# Rezoning Transportation Analysis

Petition Number: 2017-118

General Location Identifier: 04115106

**Reviewer: Eric Lemieux, PE**

DATE: 01/11/21
FILE: M21014
DRAWN BY: RST
REVISED:
JOB NO: _____
SHEET: RZ-1
OF: _____

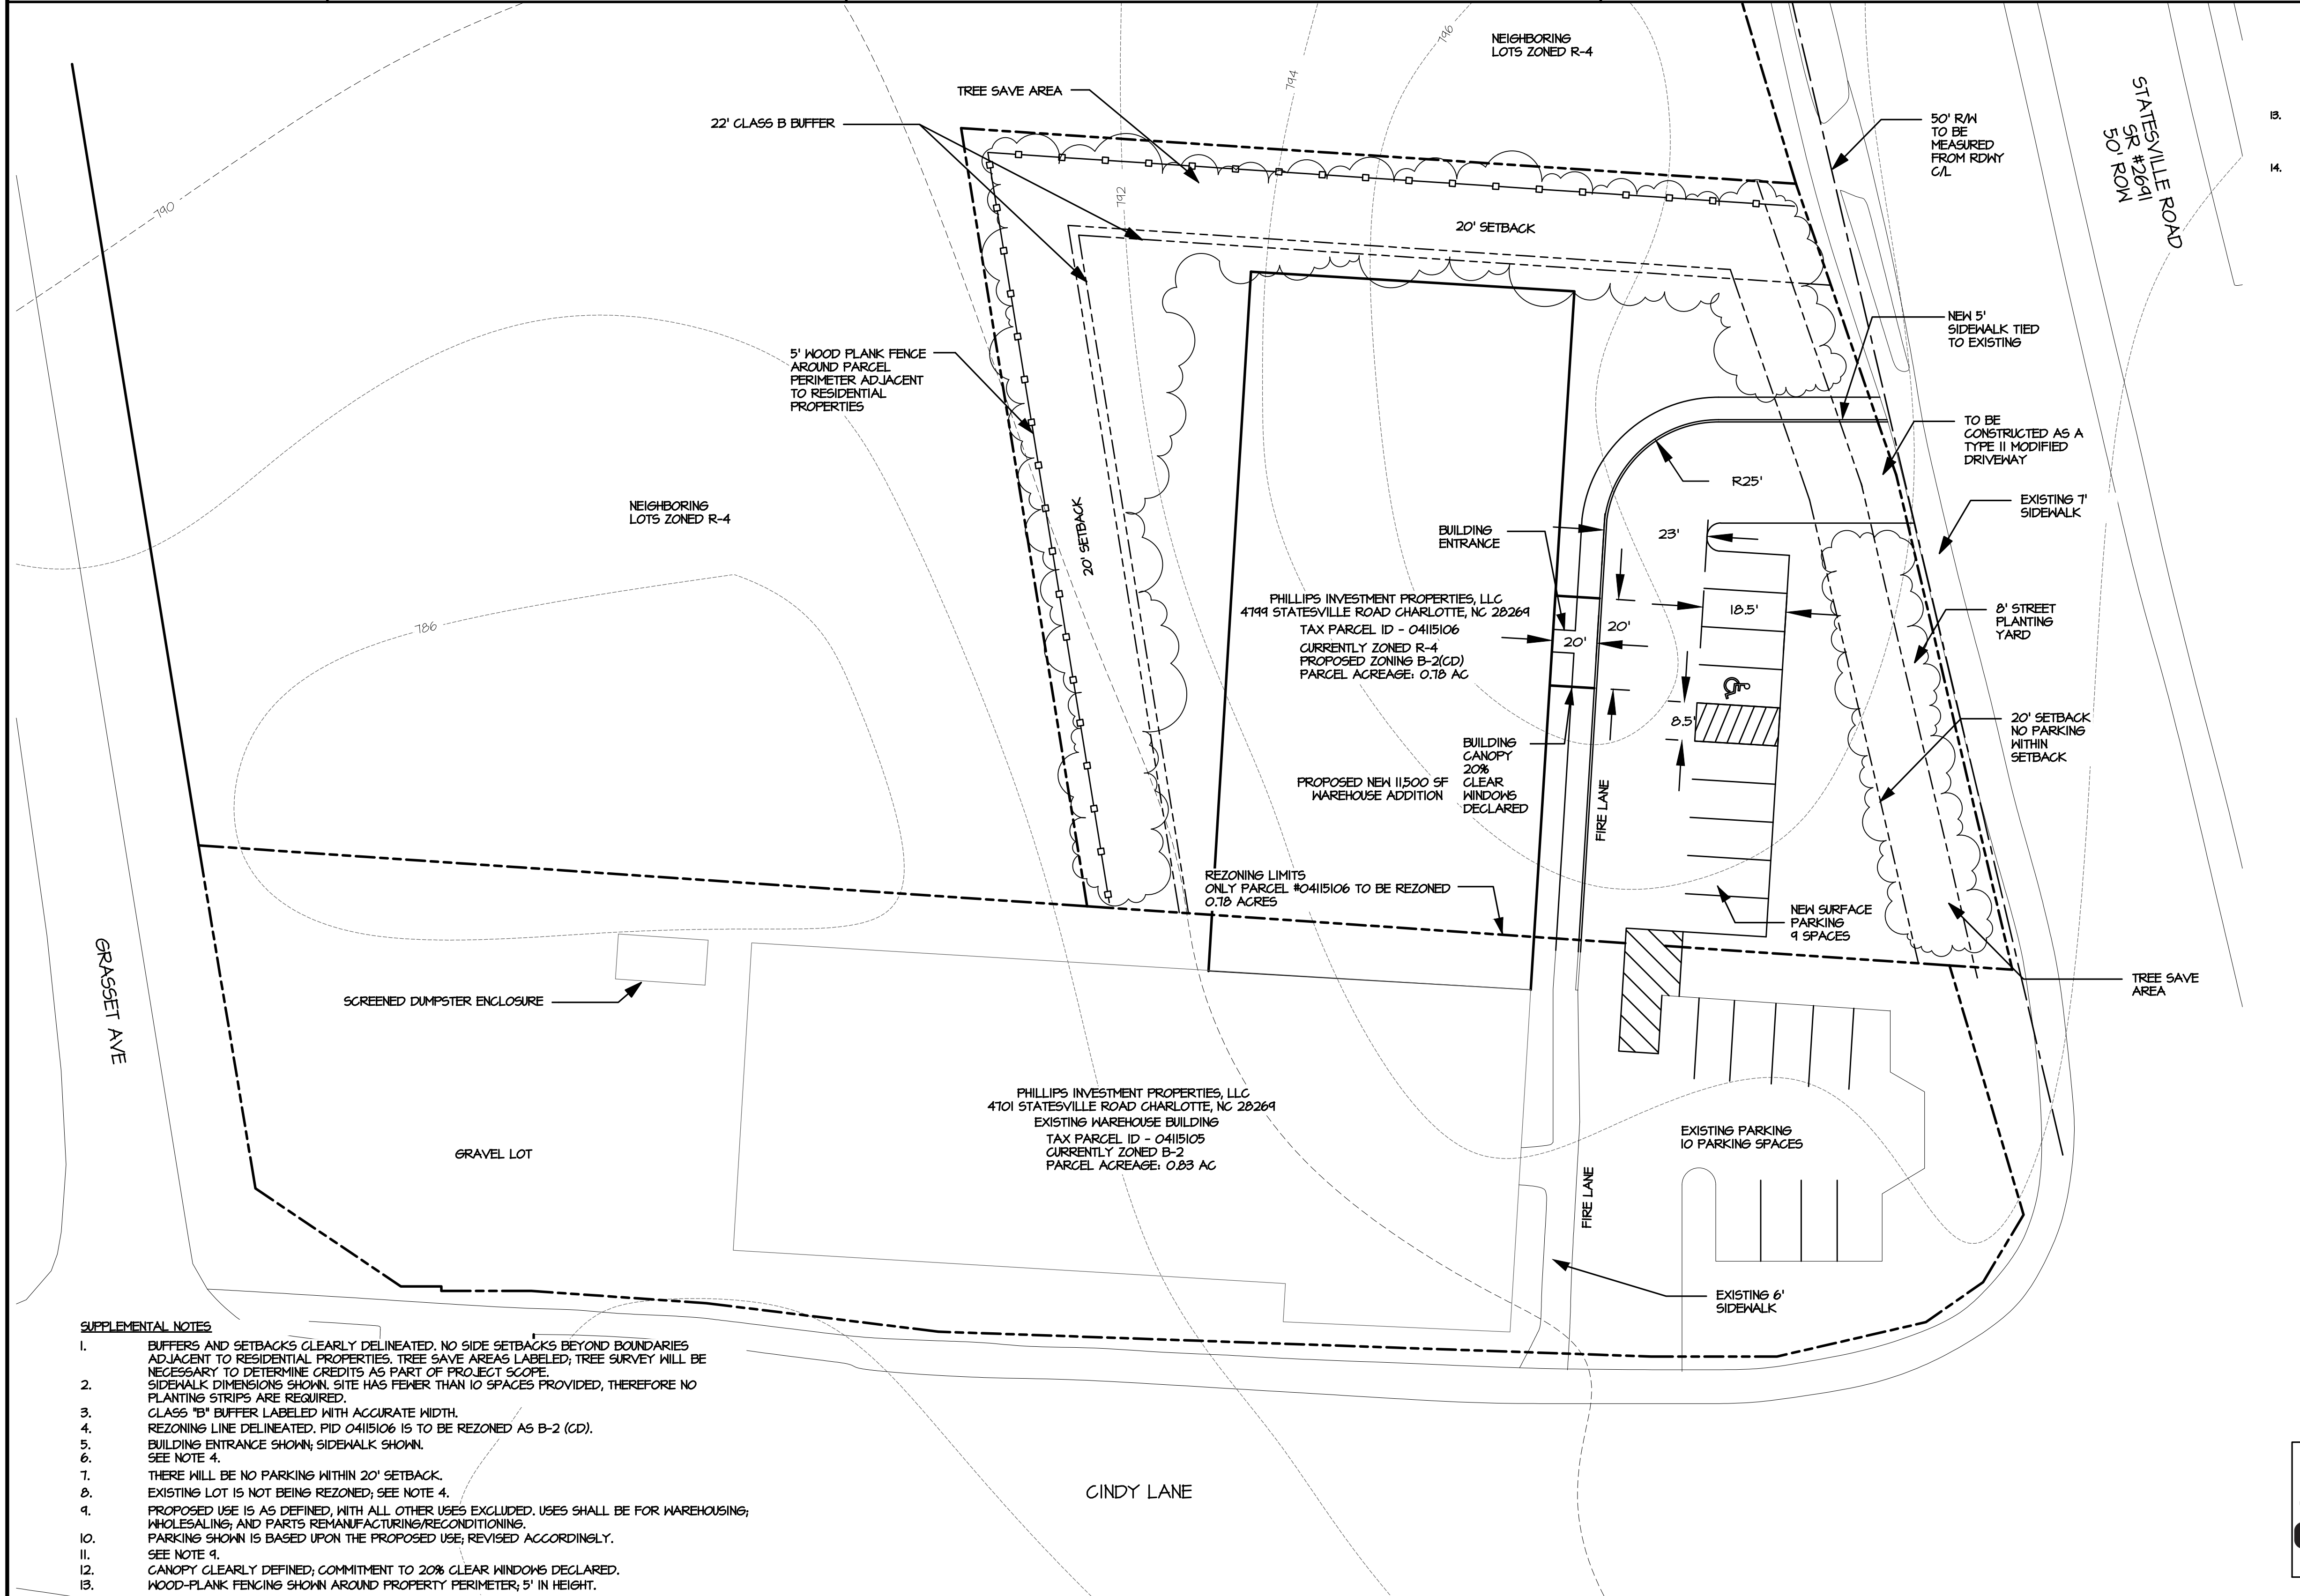
- ~~Traffic Study~~ A Traffic Impact Study/ is not needed for the complete review of this petition.
- ~~Outstanding Comment (site plan dated 05/11/20)~~ The petitioner should revise the site plan to show the driveway on Statesville pushed back away from the signalized intersection as far as possible and would need to be reconstructed as a Type II Modified Driveway during permitting. CDOT would like to see closure of Cindy Lane driveway if possible.

- Outstanding Comment (site plan dated 05/11/20)** If large trees are removed, the petitioner should reconstruct to an 8' planting strip and 6' sidewalk along frontage, as required by Chapter 19 of the City Code. The proposed planting strip must be a minimum of 8' in width. The 6' sidewalk may meander around the existing trees, if contained within a sidewalk-utility-easement, which is to be placed 2' from the proposed back-of-sidewalk. The planting strip must be installed between the existing back of curb and proposed sidewalk. Refer to the additional design references provided below.

4. **Outstanding Comment (site plan dated 05/11/20)** Revise the site plan to dimension the proposed right of way dedication from the Statesville Road centerline. **Additional design guidance is provided below.**
